CITY OF ALBUQUERQUE

**Re: Academy Dental Center
6421 Holly Ave NE
30-Day Temporary Certificate of Occupancy
Transportation Development Final Inspection
Engineer's/Architect's Stamp dated 4-3-20 (C18D038A)
Certification dated 8-24-20**

Site Plan

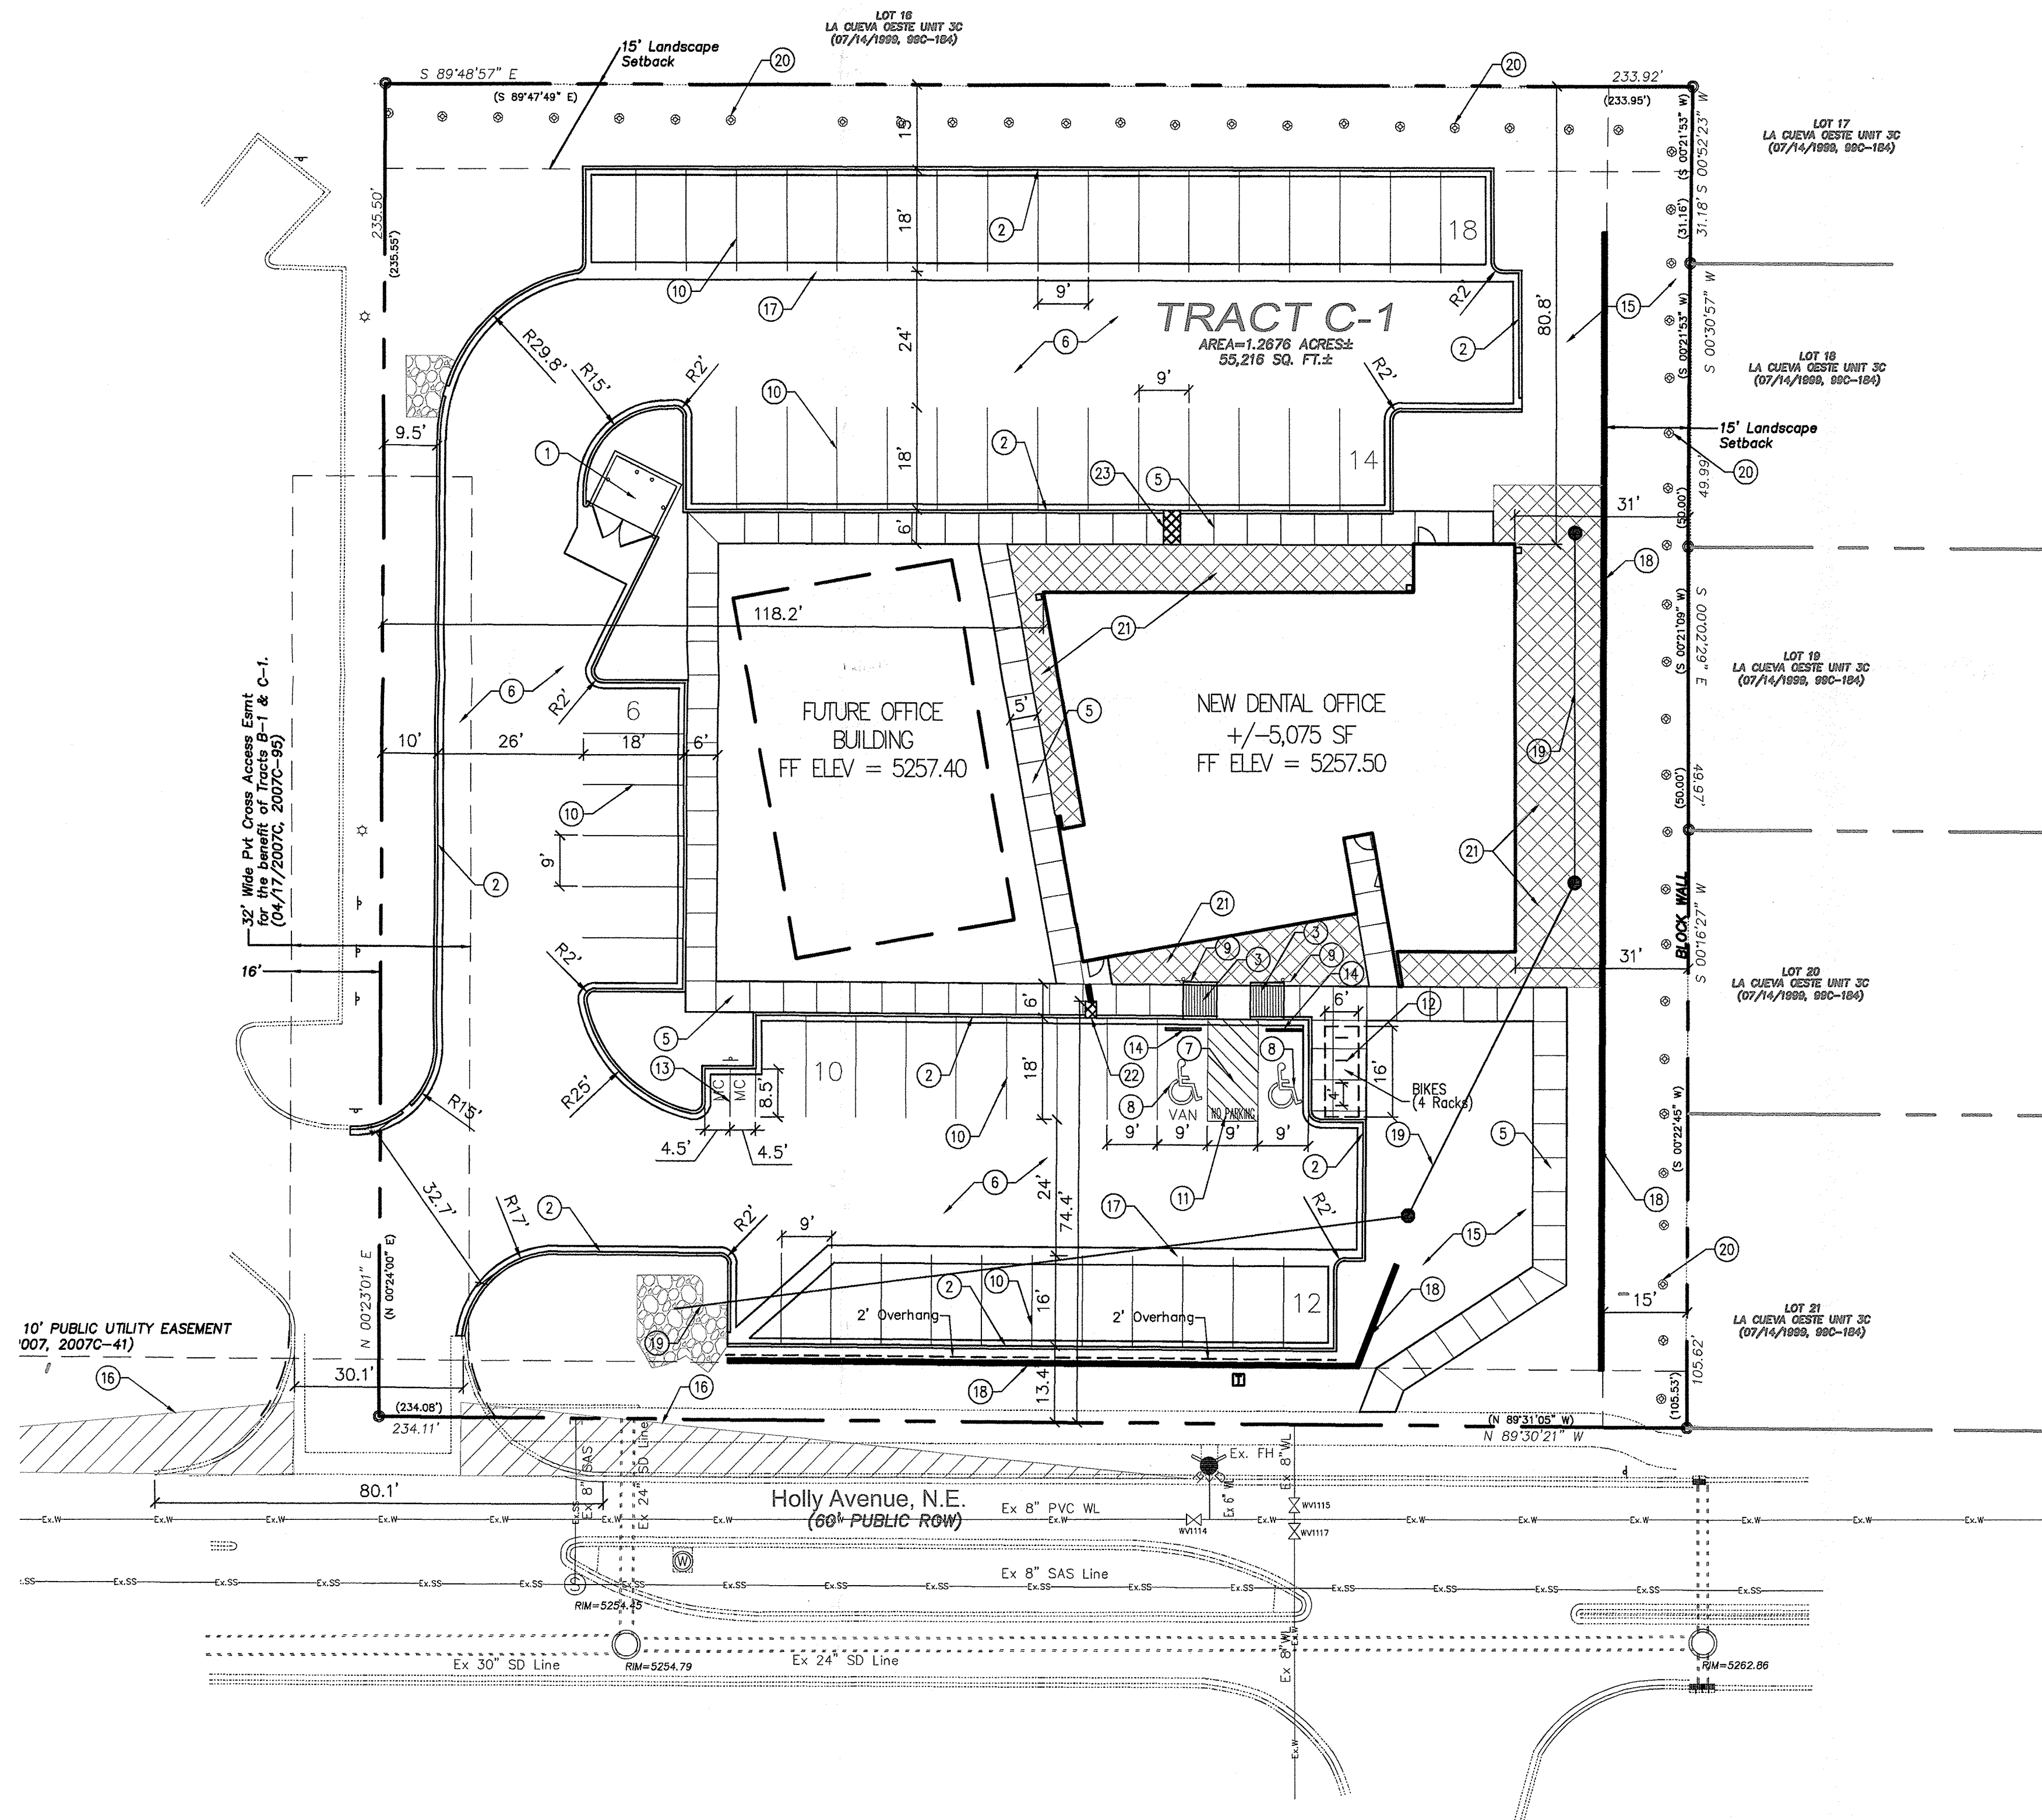
- Please add top plates to sidewalk culverts.
